FIRE RISK MANAGEMENT, INC

Memo Report

From: W. Mark Cummings, P.E.
To: Mr. Skip Reske; IDC Construction
Subject: Review of the Passive Fire and Smoke Barrier Issues

In response to a couple of recent questions regarding the need for fire and/or smoke barriers within two specific areas of the proposed design for the new Westin Hotel, I have reviewed the details of the areas in question. This review addresses two specific questions;

Sheet Title:  
**GROUND & 2ND LEVEL LIFE SAFETY PLANS**

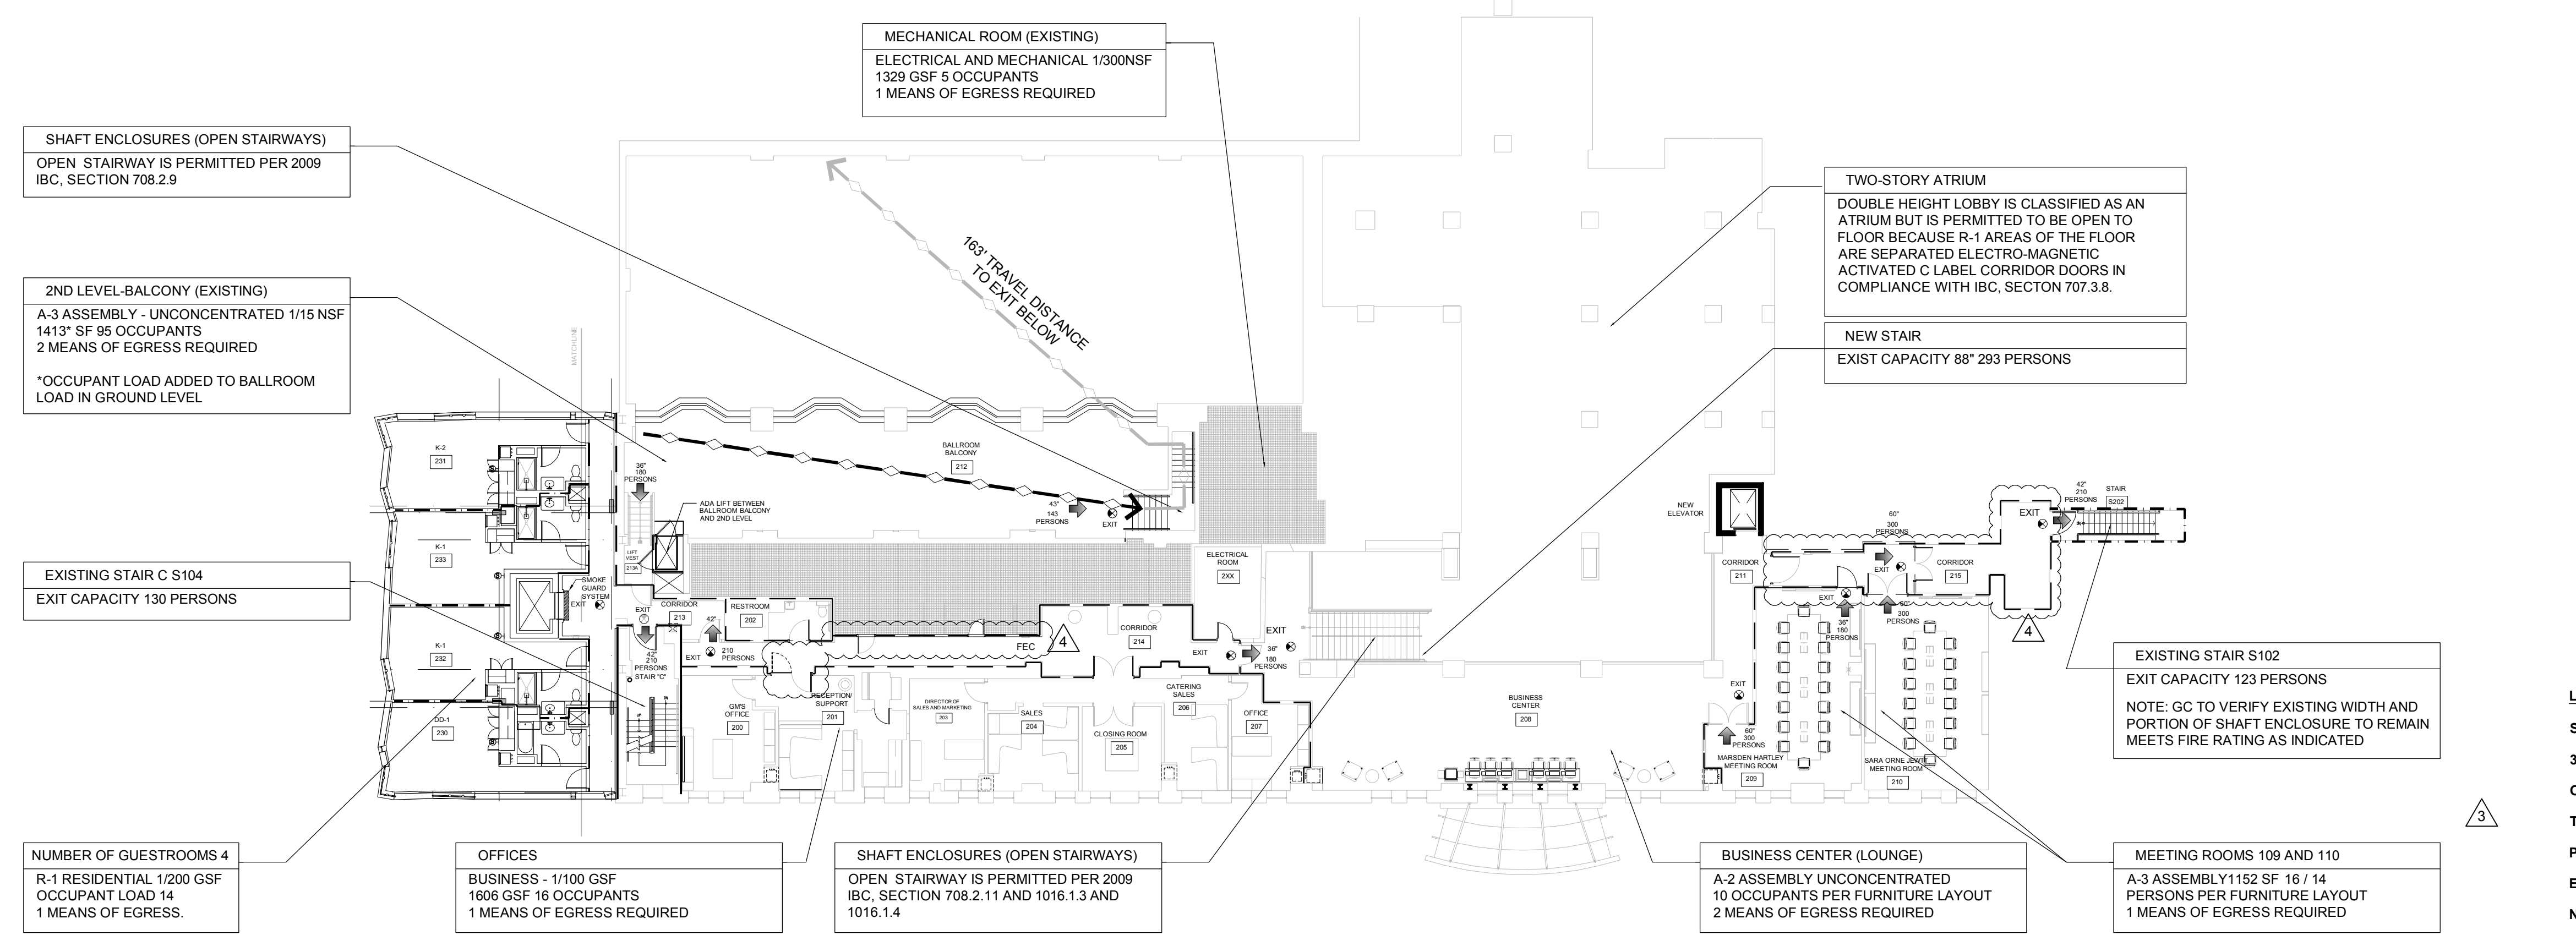
1. the need for a fire barrier, on all applicable floors, at the interface between the area that provides access to both the Service Elevator and Laundry Chute and the Elevator Lobby in the northeast corner of the hotel's tower; and
2. the need for any fire barriers within the office areas located on the Mezzanine level.

It is understood that the architectural floor plans for the Hotel's office area located at the west end of the Mezzanine level may include numerous walls that have been identified as having a fire resistance rating. Due to the fact that this building is fully protected with an automatic sprinkler system(s), none of the walls throughout all portions of the Mezzanine level are required to have any fire resistance rating. The only barriers (walls and ceilings) that must provide some measure of protection are those of the corridor(s). Any exit access corridor must be separated from the remainder of the building by barriers that are smoke resistant. This simply means that all openings in the corridor walls or ceilings must be sealed to restrict the passage of smoke. Doors leading into the corridor should be provided with automatic closing devices. The walls and ceilings, including any doors, can be constructed of any material as long as they continue to meet the "finish" requirements for this occupancy type. All other walls and ceilings separating the offices and associated spaces have no fire resistance requirements.

Sheet Title:
GUESTROOM
LEVELS
LIFE SAFETY
PLANS

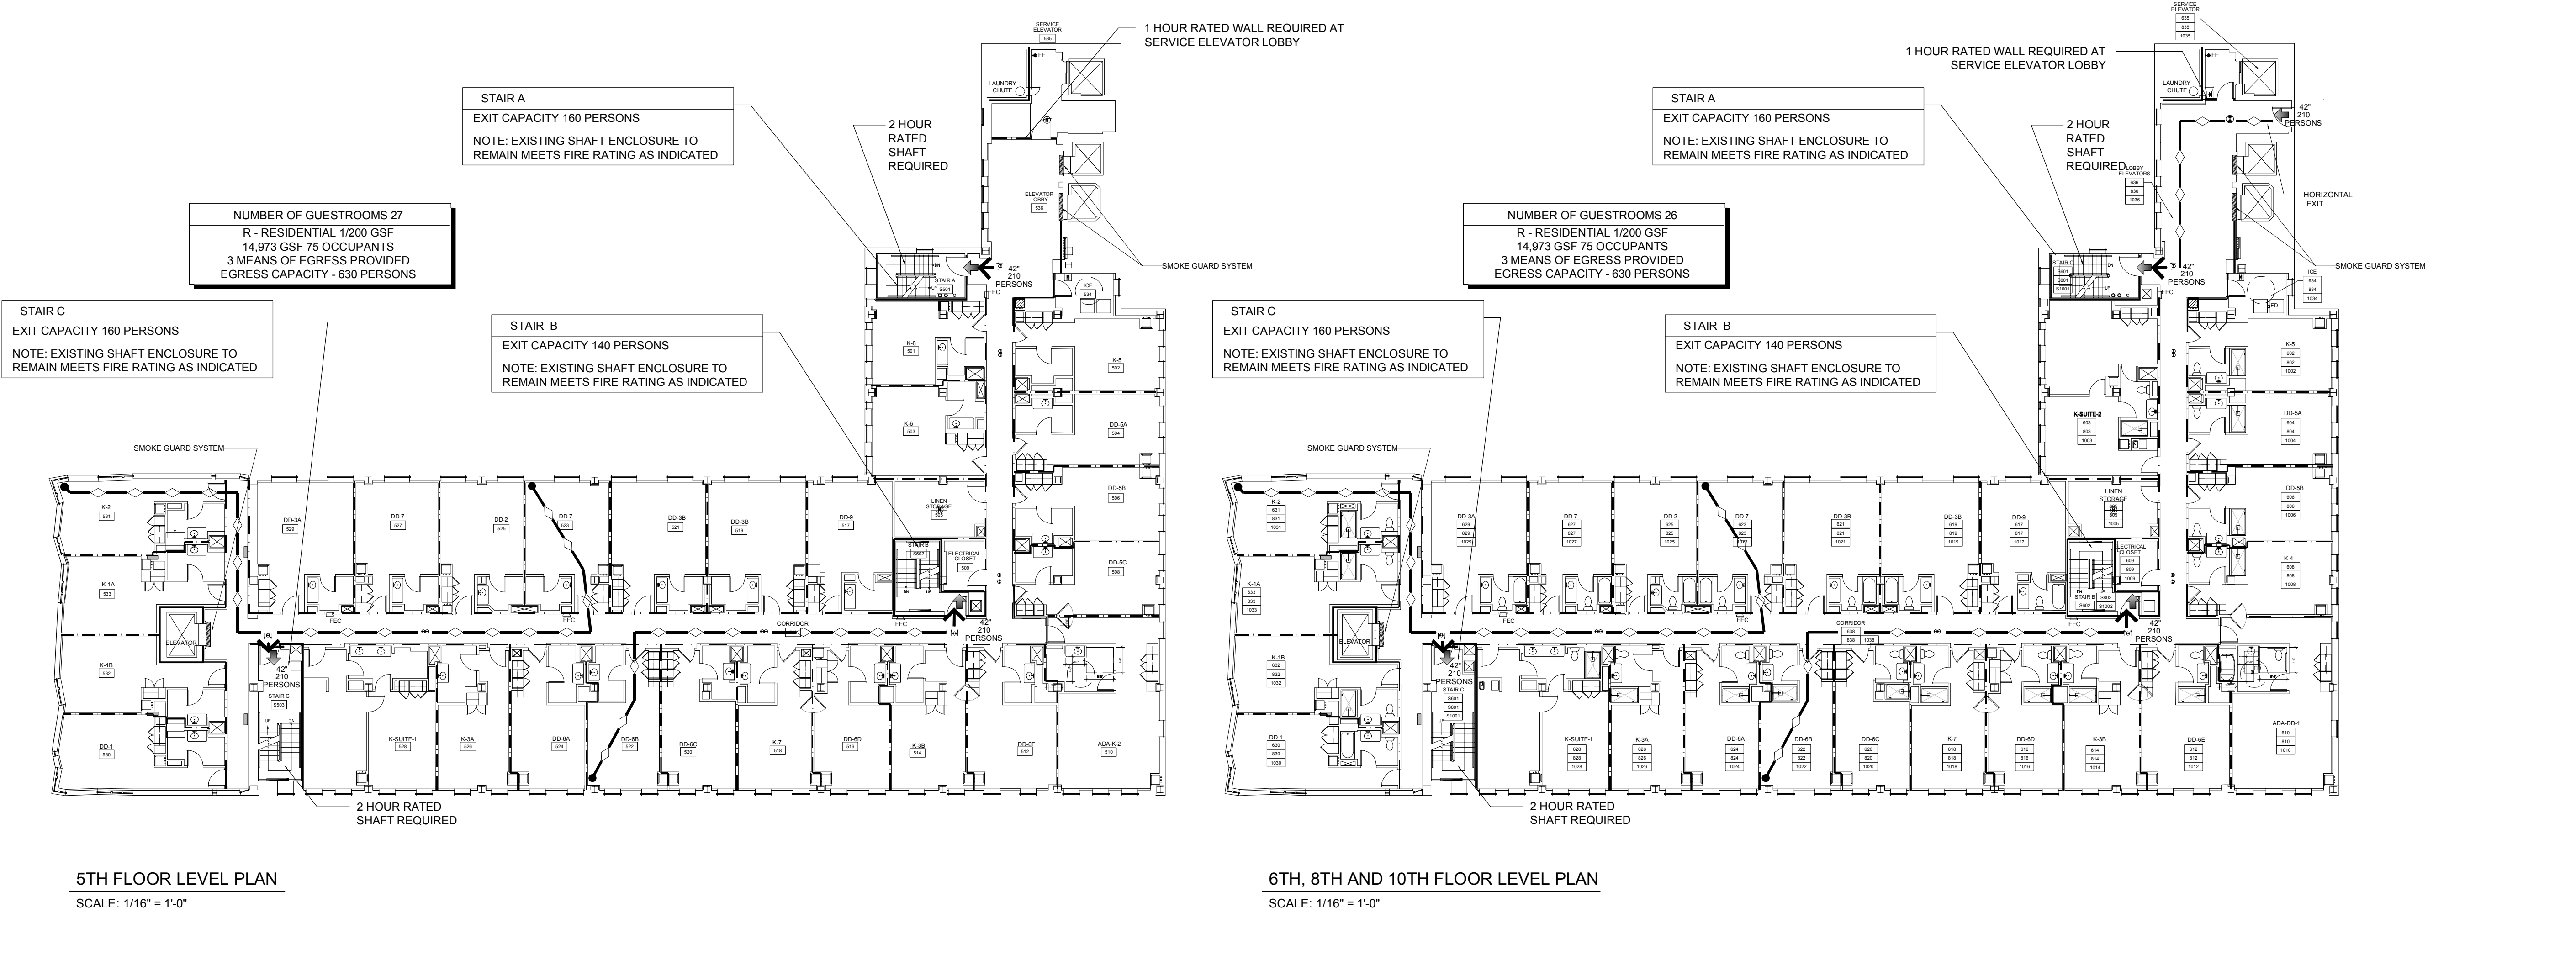
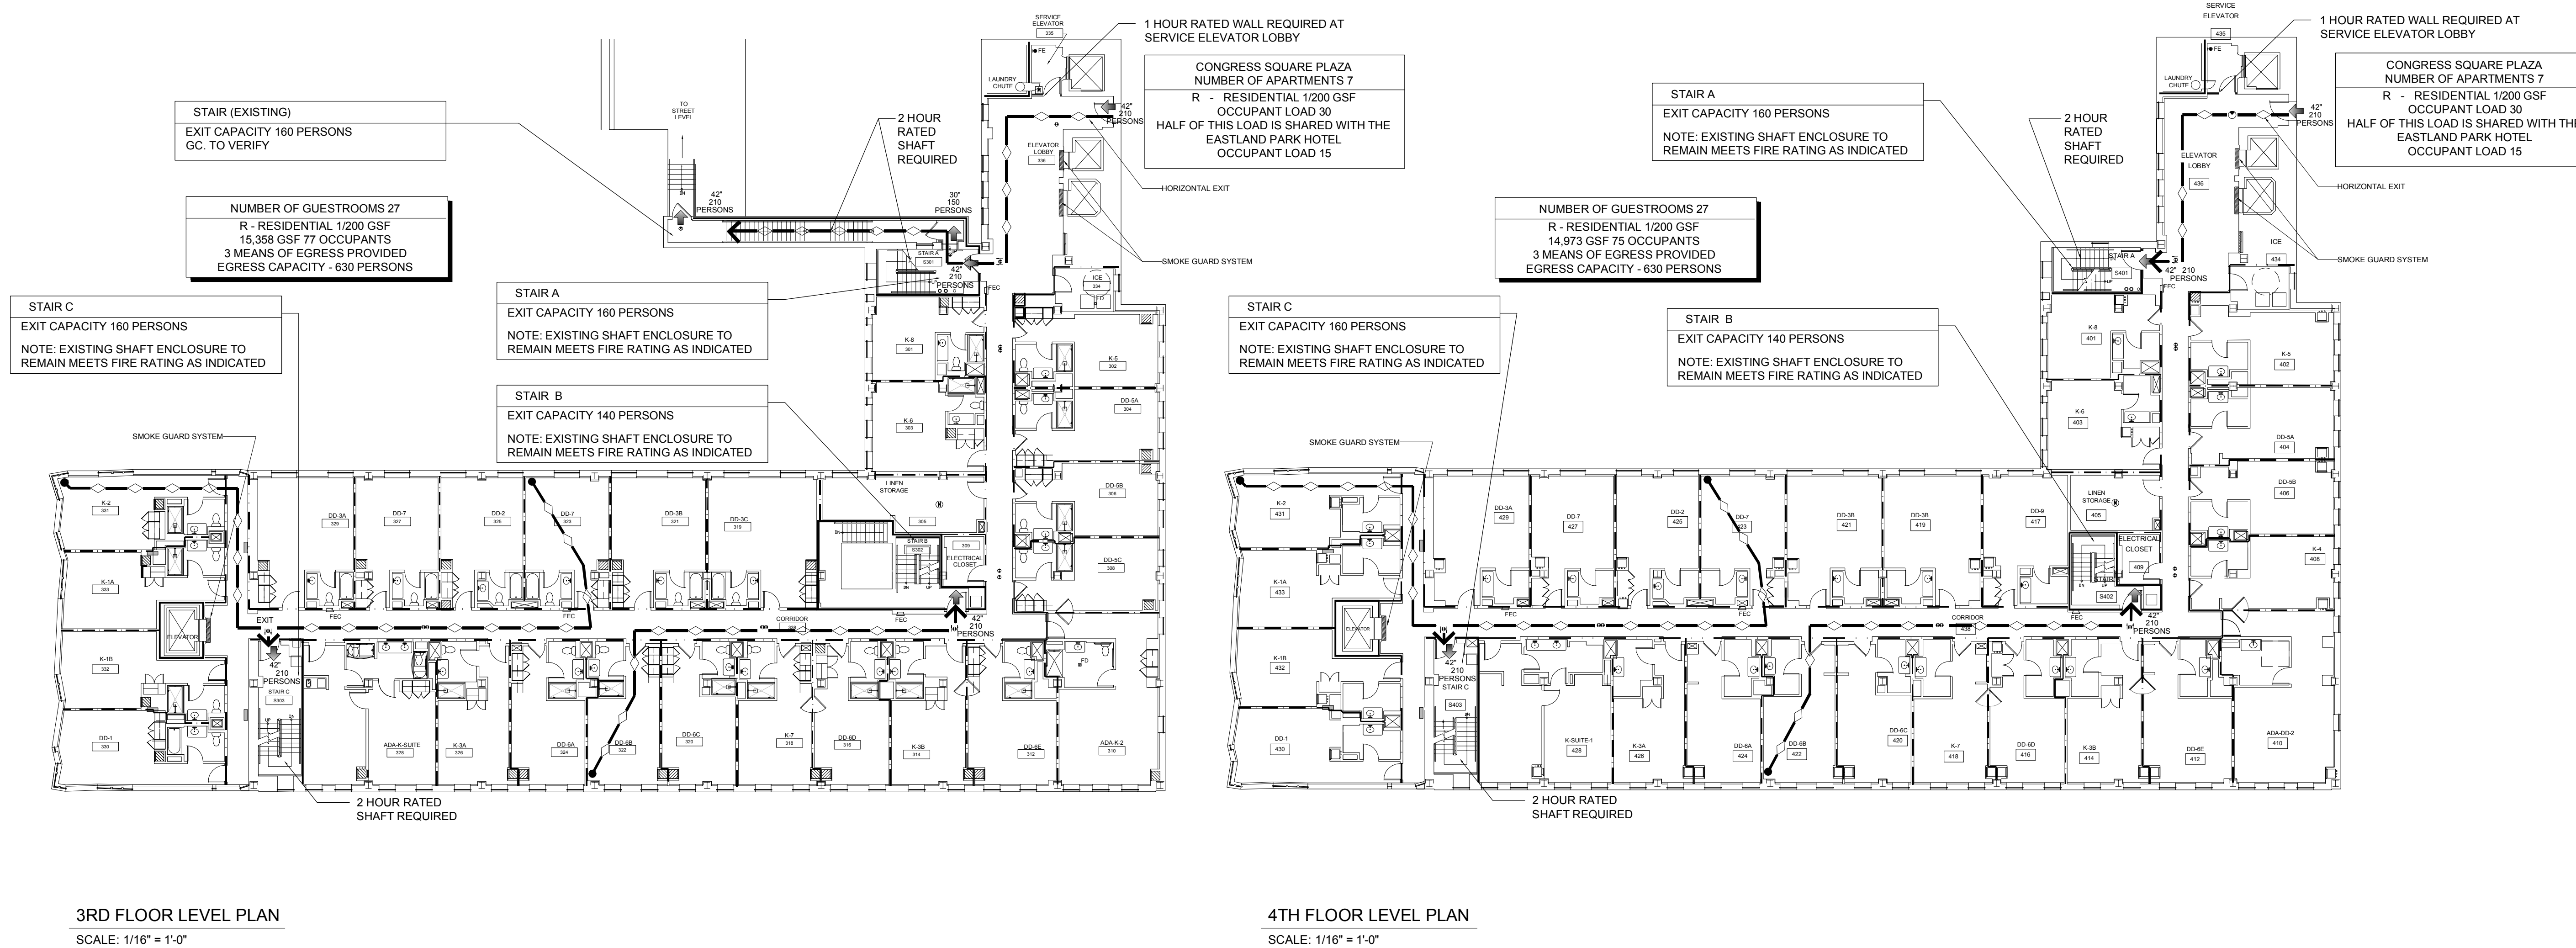
The Service Elevator and Laundry Chute are located in the northeast corner of the "tower" portion of the hotel. Access to both the elevator and laundry chute is provided via a common space. The elevator is required to be enclosed in a 2-hour fire rated shaft. Although the elevator doors are not considered to have a specific fire resistance rating, the associated elevator lobby that provides access to the elevator is not required to be separated from the remainder of the building by any fire rated barriers when the building is fully protected by an automatic sprinkler system(s). The elevator "lobby" is protected by a smoke barrier; albeit there are a number of options to meet this requirement. The laundry chute itself must be enclosed by 2-hour fire rated shaft. The doors that provide access into the laundry chute are not required to have a fire resistance rating, but the rooms into which the laundry chute opens must be separated from the rest of the building by a 1-hour fire rated barrier. As such, it is the laundry chute and not the elevator that is source for the 1-hour fire rated barrier requirement, including having a properly rated fire door assembly, to separate this area from the rest of the building.
